Comments for Deadline 2 – Cumulative traffic impacts

Sporle with Palgrave Parish Council represented by [REDACTED]

Sporle with Palgrave Parish Council (PC) wish to make a number of comments with respect to the following submissions in relation to the impacts on traffic along the A1065 during the construction phase:

Figure 2-2: Location of ATC Surveys

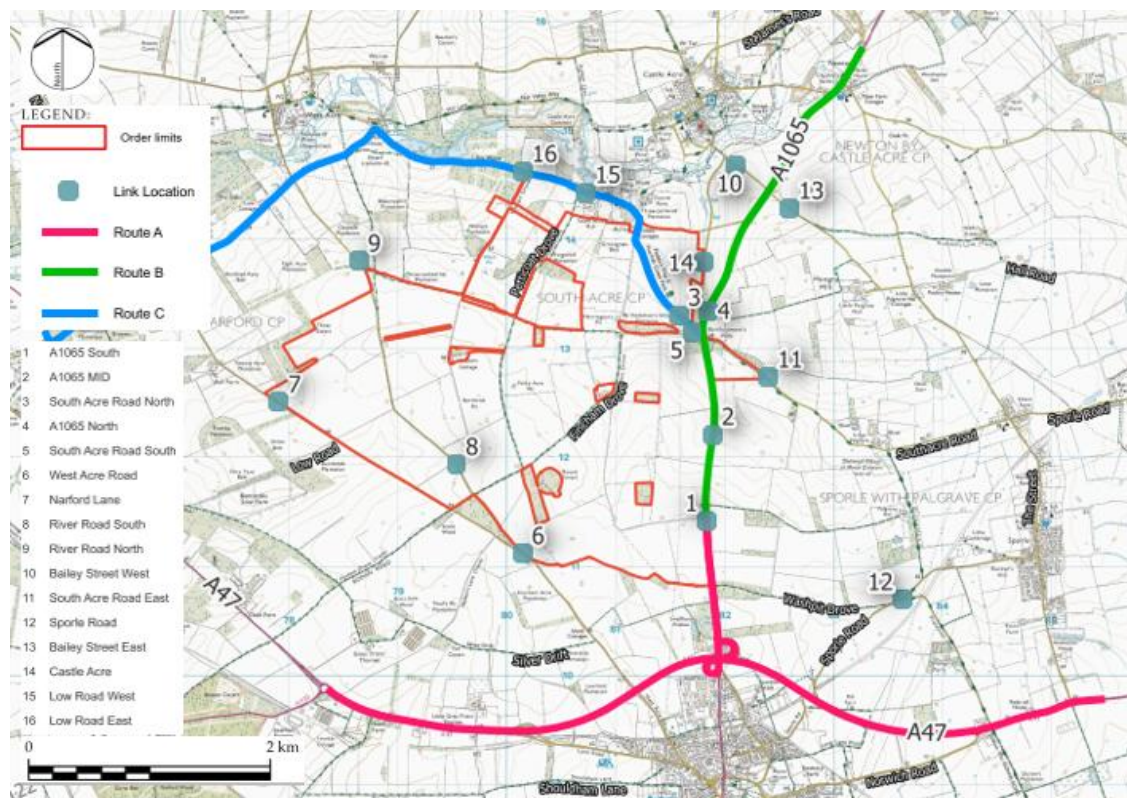
1. With reference to Table 2 below and the results of the AADT's undertaken and shown in the ES and Traffic Assessment, the baseline for 2031 does not appear to be based on the AADT done in August 2025. (This AADT was requested by NCC). This is far more representative of peak traffic flows during the busy holiday season when the A1065 is used by visitors accessing the North Norfolk Coast. The PC would contend that when using these figures, and using the same Tempro factor as used by the Applicant on the AADT October 24 figures, more realistic projected peak traffic figures for 2031 are obtained, and these should be the ones used in arriving at the increase in traffic numbers caused by construction of the scheme. This is shown on Table 2 below.

Location as shown on Fig
 2.2 Location of ATC
 surveys in Traffic
 Assessment

Figure 2-3: Collision Data Overview (Latest 3-year Period)

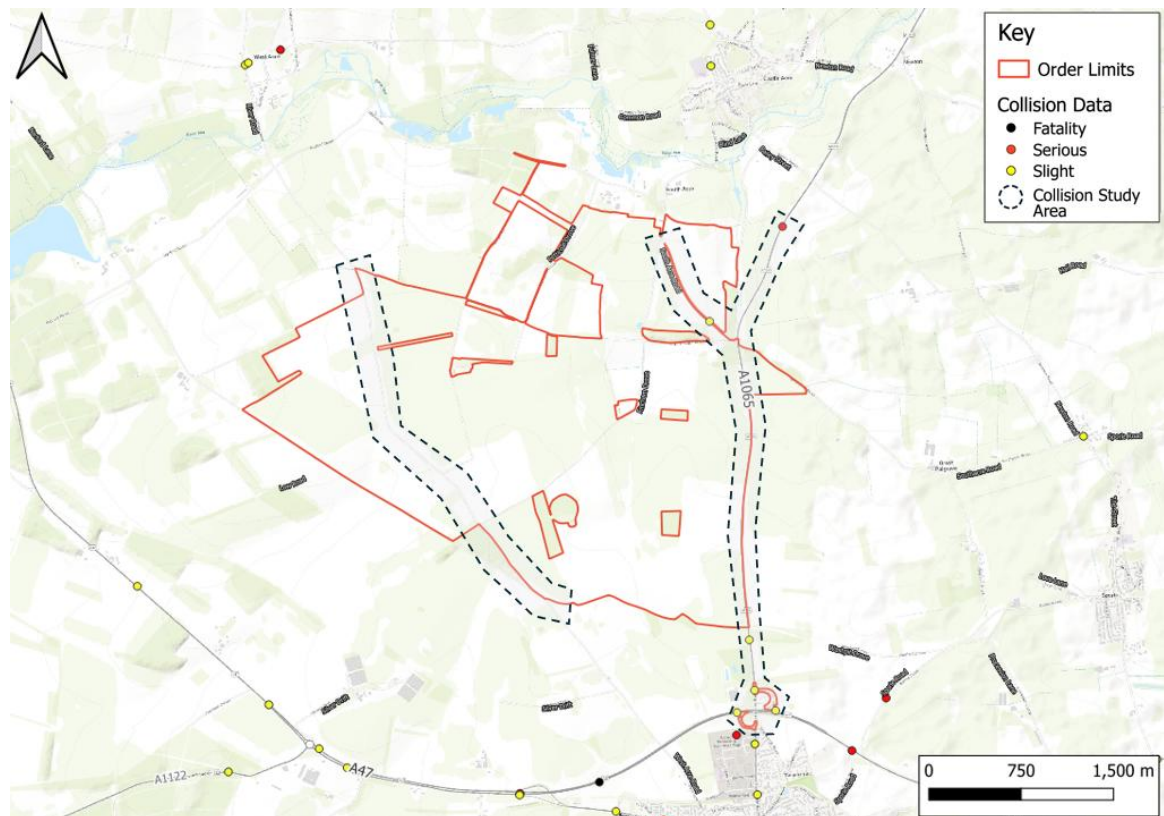
16. The review of collisions along the A1065 over the last 3 years in the Traffic Assessment concludes that there are no existing highway safety concerns. However, the A1065 is considered to be by many in Norfolk to be the most dangerous road in the county and six accidents causing injury in that period will do nothing to allay that concern. With increasing delays on the A1065 during the construction of both Drovers and High Groves and the likelihood of increased traffic on associated minor roads as a result, the PC is concerned for road safety.

Figure 3-1: Proposed Access Overview

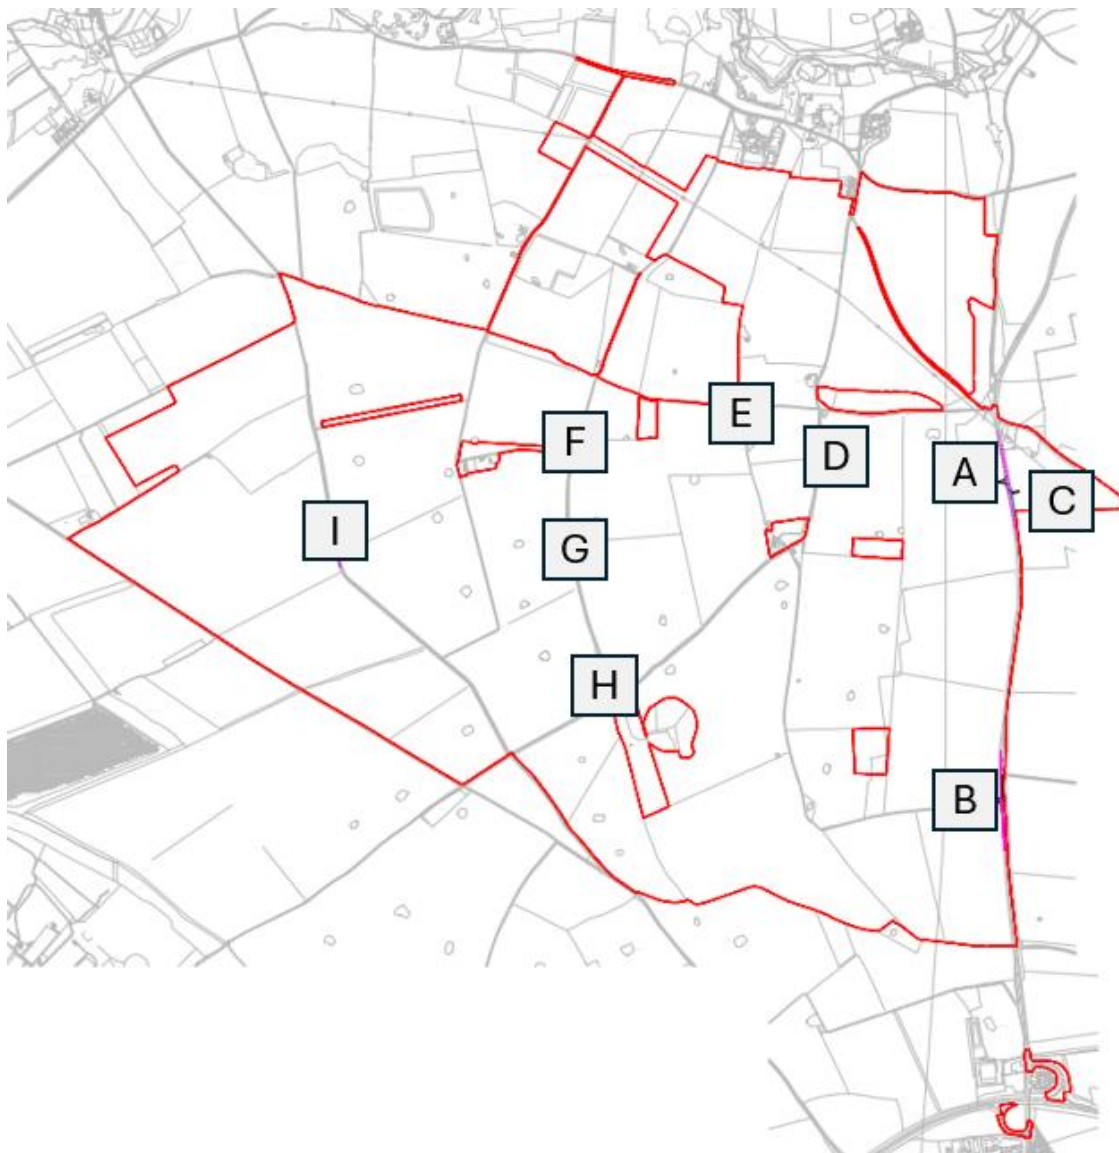
8. The PC would wish to add their concern that this be clearly secured at this stage in the oCTMP as part of the DCO and any subsequent CMTP.
9. The overarching concern is the disruption to traffic traveling on the A1065 by the fact that there could be 4-5 construction access points between the A47 junction with the A1065 and where Southacre Road crosses the A47 just beyond Drovers access A and temporary access C as shown in Fig3.1 of the Traffic Assessment.

<i>Access</i>	<i>Development</i>	<i>Distance from A47 junction</i>	<i>Distance from last access</i>
AP02	High Grove area C02 west of A1065	560m	N/A
B	Droves west of A1065	1184m	624
AP01	High Grove area C03 east of A1065	1312m	128m
C	Droves temporary access to east of A1065	Approx 2300m	988m
A	Droves access to west of A1065	Approx. 2400m	100m

Table 1 shows that over a distance of approximately 2.4km (1.5 miles) there will be possibly 4-5 construction accesses. This will cause considerable disruption with far reaching consequences if not properly managed and the PC is very sceptical of the general view of the Applicant and the traffic authorities that this will cause only insignificant impacts.
